Application for a non-material amendment following a grant of planning permission.

Number	120
Suffix	
Property name	
Address line 1	Laund Road
Address line 2	Salendine Nook
Address line 3	
Town/city	Huddersfield
Postcode	HD3 3TY

Demolition of Existing Dwelling and erection of 7 No. Dwellings	
Reference number:	2019/90486
Date of decision	12/06/2020

Raise Plot 2 by 350mm

NORTH ELEVATION

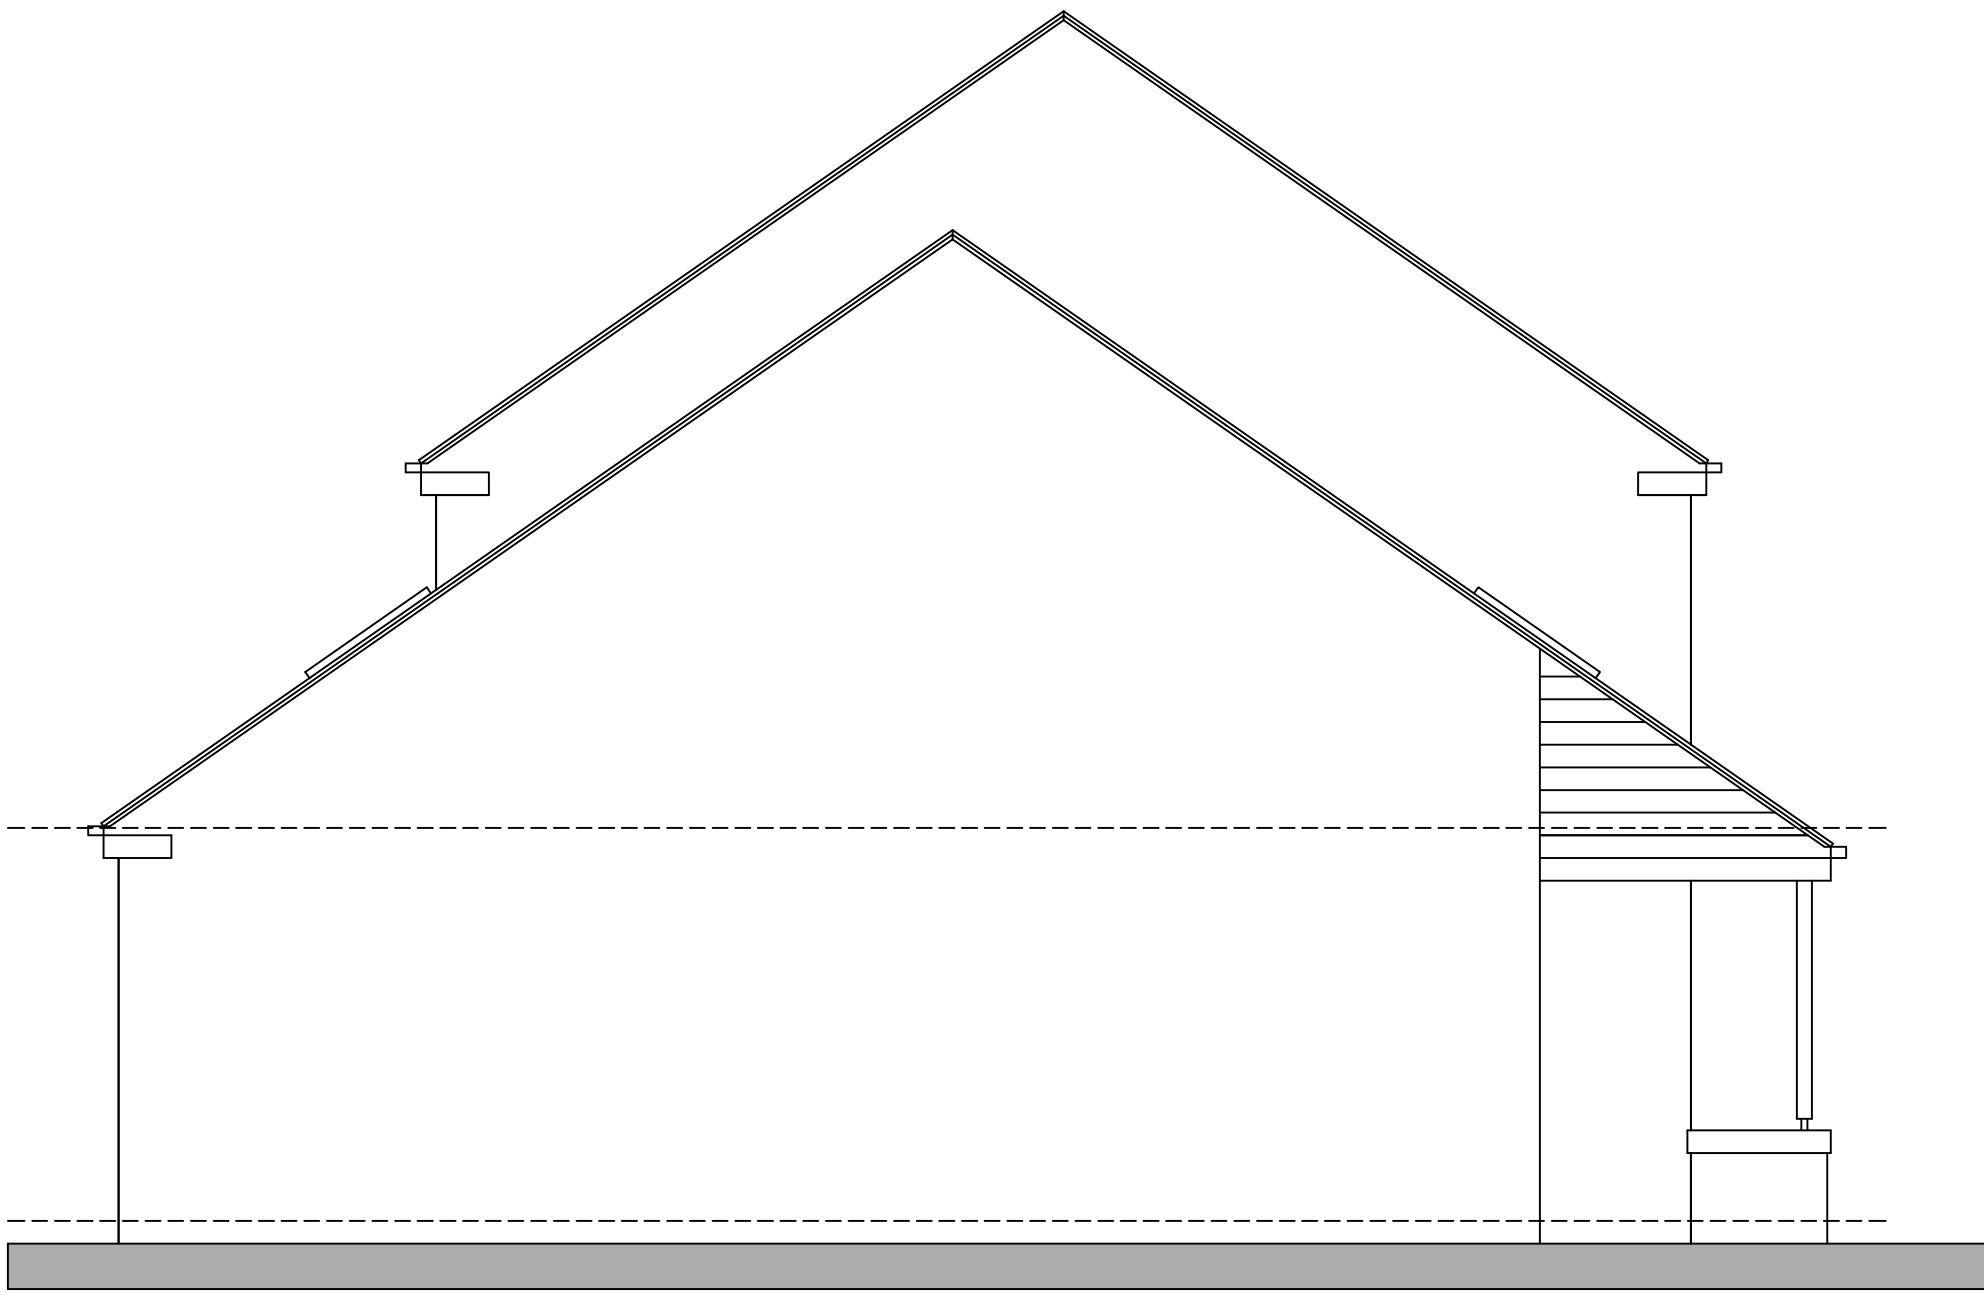
Due to the floor construction changing, from solid to suspended beam and block, due to incorporation of gas membrane
